Re: Framing Items – Blanket Report
Atherstone Community
Rolen Plan

The client referenced above requests **Queen City Consulting and Design, PLLC** to evaluate alternative framing items at the community referenced above. The structural plans were provided by Queen City Consulting and Design. All orientations in the report reference directions as if the reader is viewing the front of the house from the street.

SECOND FLOOR PLAN

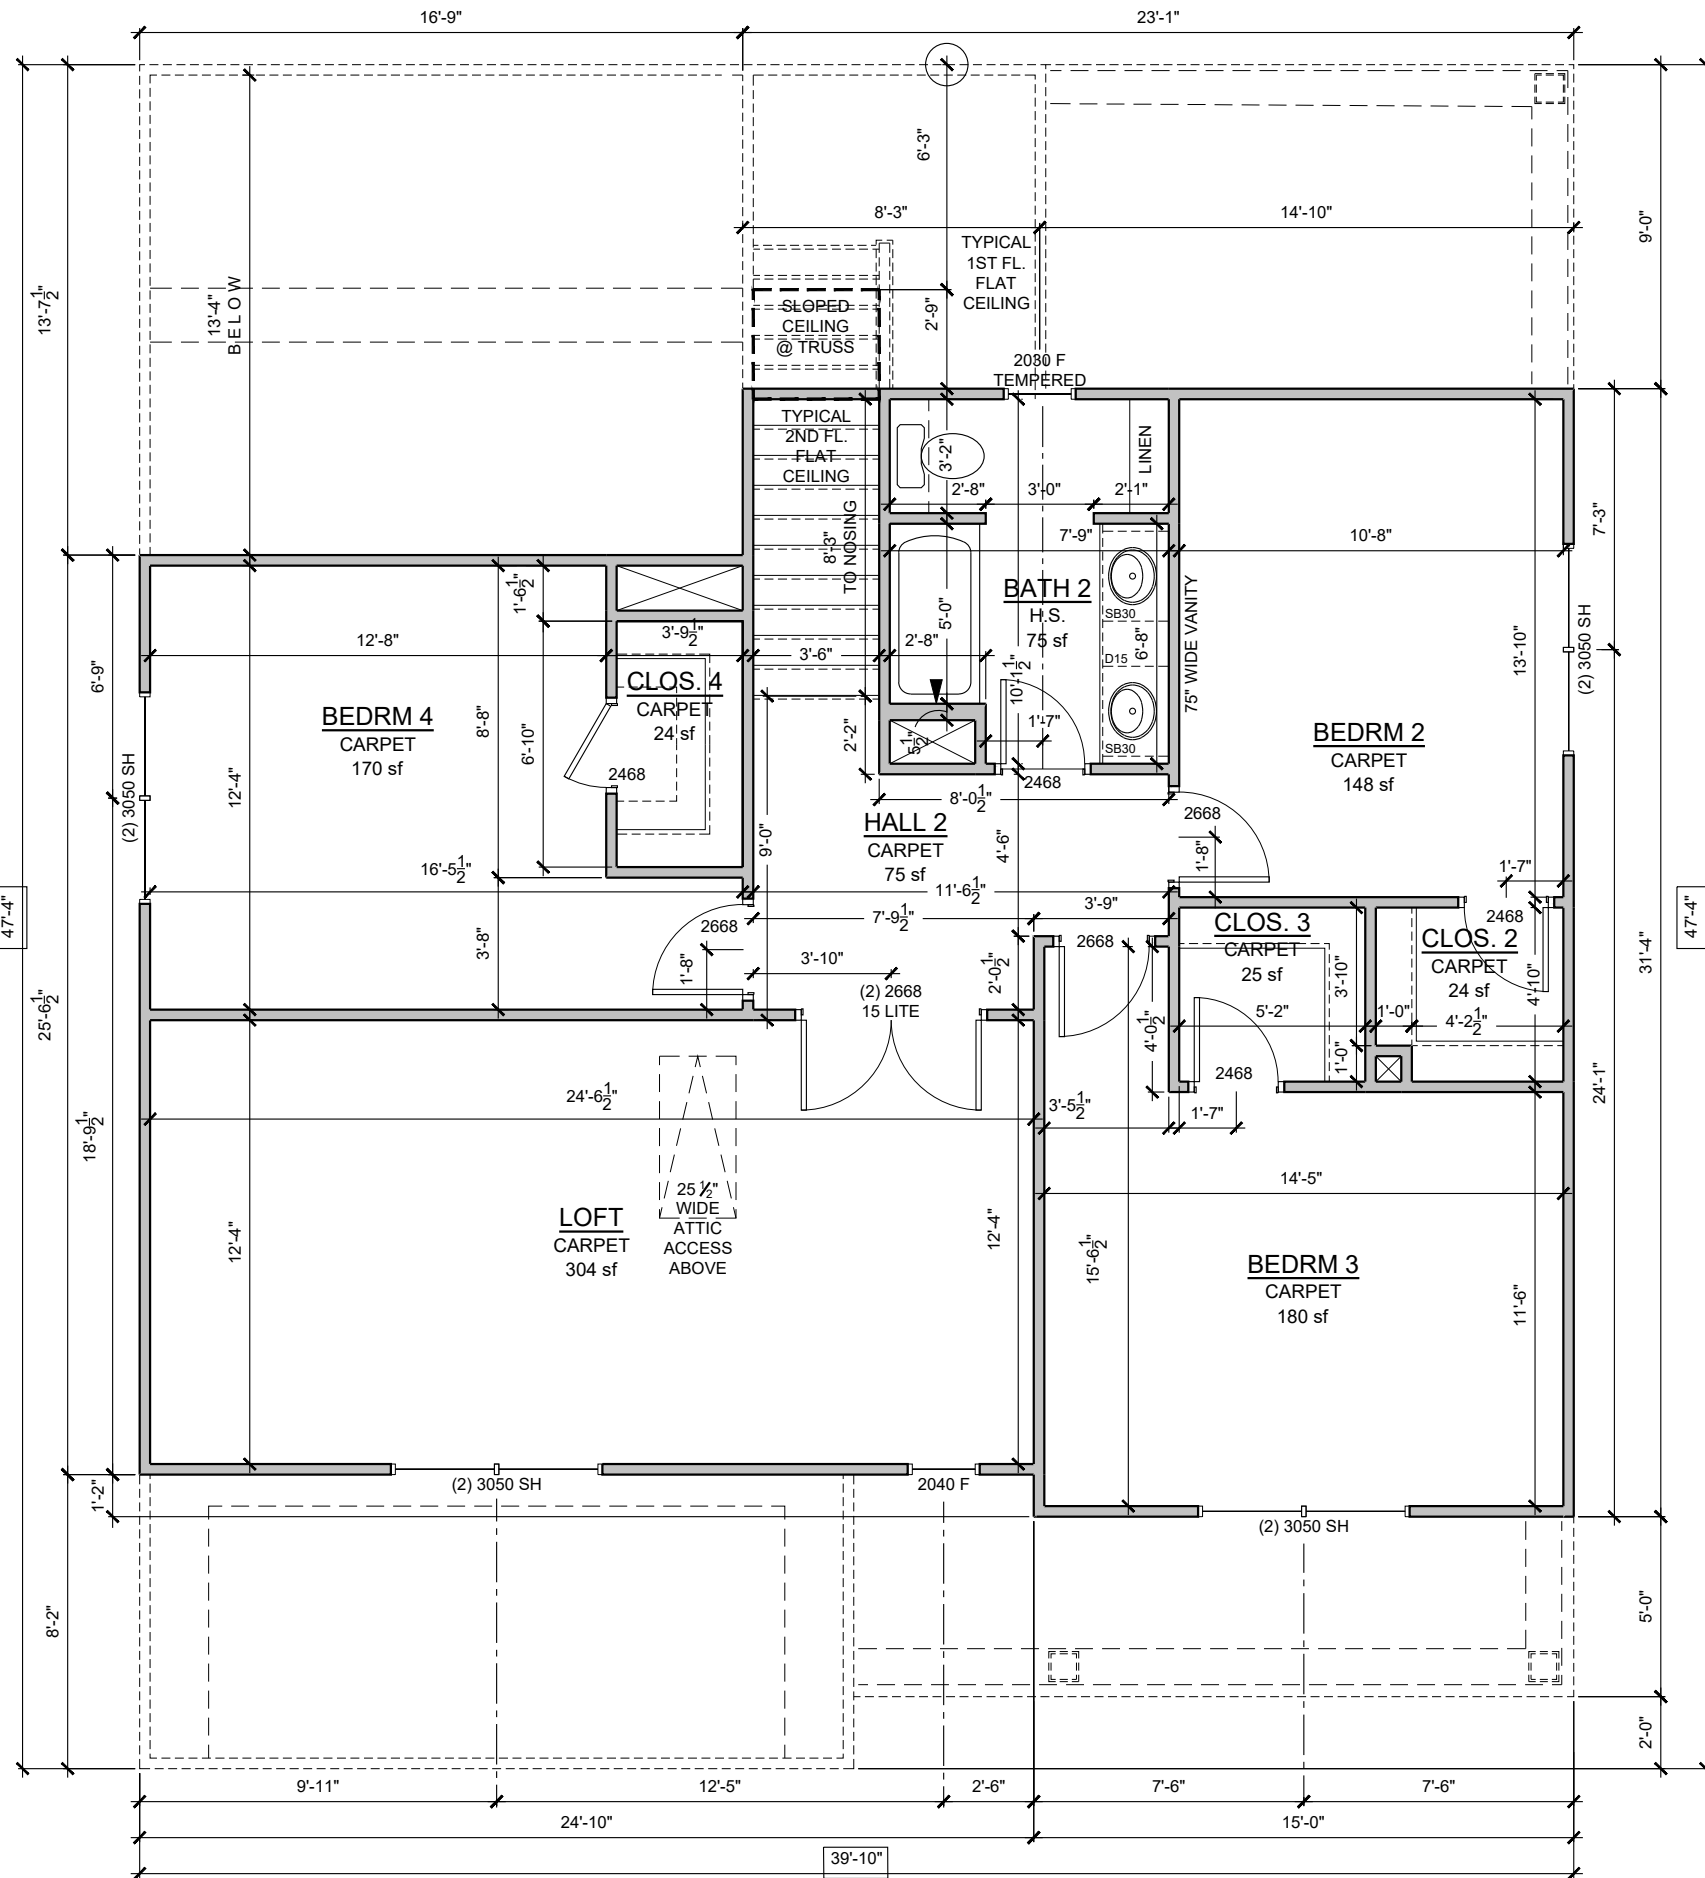
The contractor has requested specifications for the header located at the framed opening to the master bathroom.

Based on our review, the contractor shall install a 2-2x6 header with (1) 2x4 jack stud and (1) 2x4 king stud at each end. See plan snippet below.
